**WELWYN HATFIELD BOROUGH COUNCIL
EXECUTIVE DIRECTOR - PLANNING, PUBLIC PROTECTION AND GOVERNANCE**

Application No: 6/2018/1603/HOUSE
Location: 78 Bell Lane Brookmans Park Hatfield AL9 7AY
Proposal: Erection of a front garage extension with pitched roof
Officer: Mr William Myers

Recommendation: Refused

The Contractor, and all specialist Sub-contractors are to check all levels, dimensions and features on site prior to performing any element of work or installations. Any and all discrepancies are to be reported immediately to MD Designs for decision.

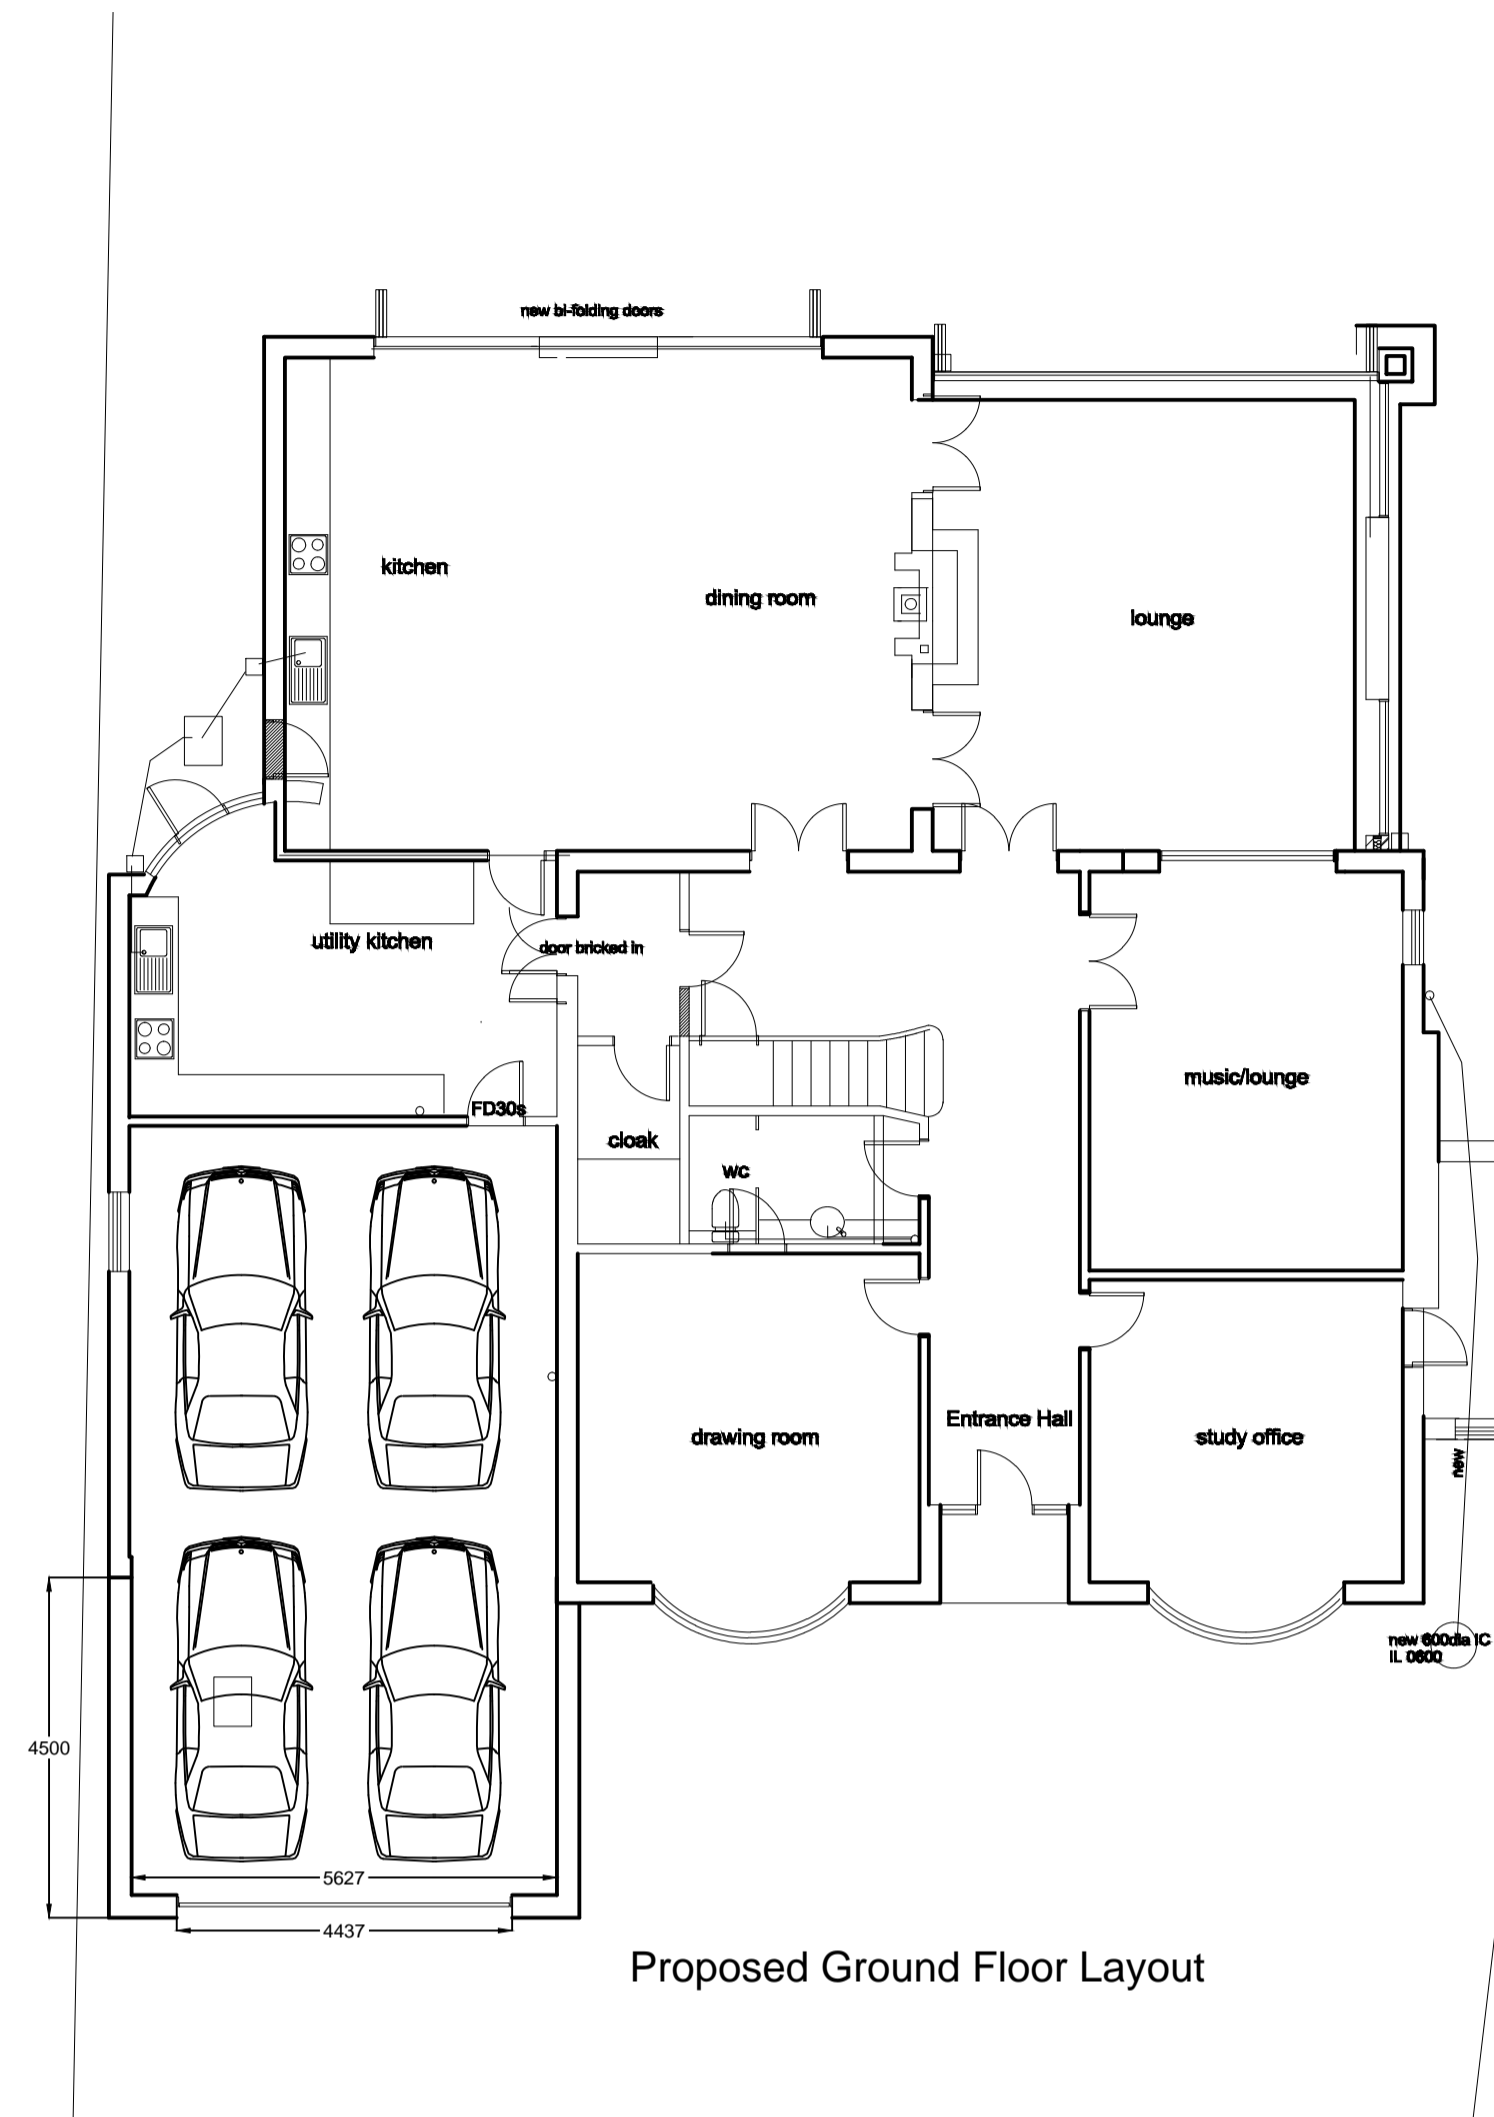
The proposed front extension would project approximately 4.2m forward of the existing front elevation of the property, with a width of approximately 6.3m. The extension would have a pitched gable end roof which would match the existing angle of the other front facing gables within the existing front elevation of the dwelling, with a height at its ridgeline of approximately 4.8m.

Although the proposed extension would not be as high as the existing two storey feature at the centre of the front elevation, it would be approximately 1.3m greater in width than this feature and its proposed roof structure would be noticeably larger than all the other existing front facing gables. This disparity in the size of the front facing gable features is most striking when the existing gable on the opposite side of the dwellinghouse is compared with the proposed gable ended projection. This is because the existing feature only has a width of approximately 4.6m compared to the proposed width the extension which would be 6.3m and would be approximately 0.3m greater in height. This feature would create a lack of symmetry when the property is viewed from the front and this would be made more noticeable by the fact that, unlike the existing front facing gable feature on the opposite side of the dwelling, the proposed roof structure would be almost touching the bottom corner of the dormer window at this side of the dwellinghouse.

It is unclear from the submitted drawings how the proposed extension would intersect with the existing projecting gable and how the roof, eaves and gutter detail along the flank elevation would be constructed. It appears that part of the roof would be flat or could possibly feature a large gully. This, together with the desire to avoid the dormer, has resulted in an off-centre and asymmetrical roof form to the proposed extension.

In addition, unlike the other front facing gable features at the front of the property, the proposed extension would project 4.2m beyond the existing front elevation of the dwellinghouse and would therefore create a dominant feature to the front of the property which would fail to adequately respect, or relate, to the existing design and appearance of the host dwelling. Furthermore, it is considered that these comparisons demonstrate that the size of the proposed extension would fail to be subordinate, or subservient, to the existing dwellinghouse.

The submitted plans do not indicate what materials the proposed extension would be constructed from but it is considered that subject to a condition being imposed that the extension be constructed out of matching materials to the existing dwellinghouse that this aspect of the proposal would not be unacceptable.

2. By reason of its size, bulk and design, the extension would fail to appear subordinate or subservient in scale, resulting in an excessive and contrived addition which would fail to adequately respect, or relate, to the existing dwelling. Furthermore, the proposed extension would create a dominant feature to the front of the property which would harm the character and appearance of the host dwelling and the surrounding area. The proposal is therefore of poor quality design which fails to comply with the National Planning Policy Framework 2018, Policies D1 and D2 of the Welwyn Hatfield District Plan 2005 and the Supplementary Design Guidance 2005.
